Arborfield & Newland Parish Council

7th January 2016

Response to the Examining Authority's second written questions (as issued on 11 December 2015)

Question 4.7.4 iii – Re the Arborfield and Newland Parish Council's issues concerning reflected noise from barriers on the opposite side of the M4, can the Parish Council please identify precisely the locations with which they are concerned? The use of a map would assist.

Project	SMART MOTORWAYS PROGRAMME
	M4 JUNCTIONS 3-12
Drawing title	ENVIRONMENTAL MASTERPLAN
	REGULATION 4(2)(e)
	SHEET 14 OF 61
	LOWER EARLEY

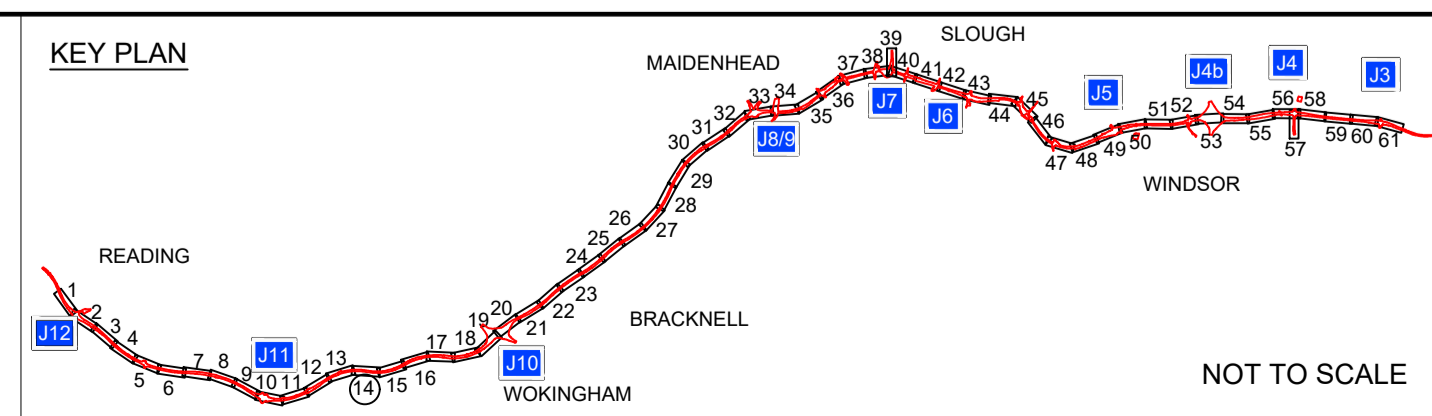
- 1 In our original submission, made in July 2015, we raised concerns regarding the possible impact, on properties in the Parish south of the M4, of noise that would be reflected from any new barriers erected on the north side of the M4 as part of the Smart Motorway scheme.

- 4 When Earley Town Council signed the Statement of Common Ground relating to impacts of the proposal, we noted that it had been accepted that noise impacts on Lower Earley would be negligible. However, given that others continued to lobby for additional barriers on the north side of the motorway, the Council wrote to Highways England, and to the

- 7 The Council remains concerned about the reflected noise issue, principally now because we are not certain what may eventually be incorporated into the scheme proposals, either arising from the study of additional mitigation, or in response to proposals being made by others.

- 5 We received a most helpful reply from Highways England, dated 4 December 2015, which confirmed that the only new noise barriers being proposed between Junctions 10 and 11 are either side of Mill Lane bridge, Sindlesham, about which the Council has no concerns.
